# CITY OF ALBUQUERQUE

**Re: Mirehaven Improvements Grading Plan  
Engineer's Stamp Date 4-15-14 (H09D017D)**

## COA

**Meeting Objective:** Discuss Mirehaven Arroyo Improvements Report and Plans

J TYPICAL GRADE CONTROL STRUCTURE SECTION J-J

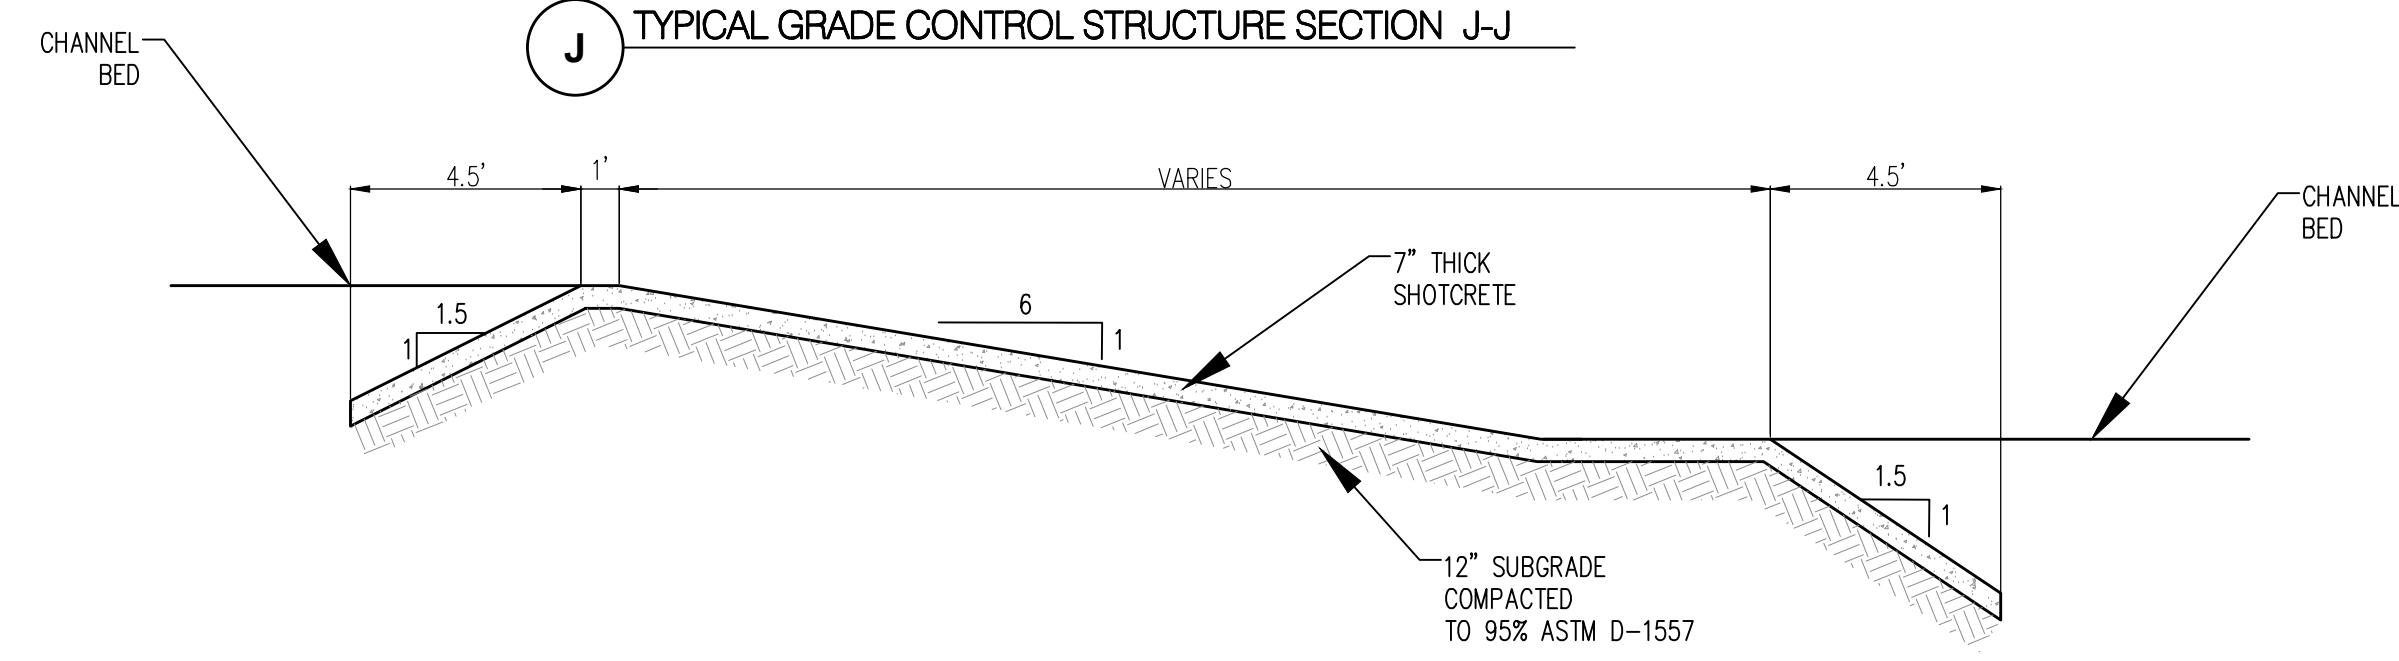
There was a general discussion on drop structures and the details of the final design. The final design reflects the drop heights and locations based on the easement boundary, the grade needed in the arroyo and the adjacent subdivision grades outside the arroyo. A profile with the proposed grades, the previous design grades, and the existing grades was reviewed.
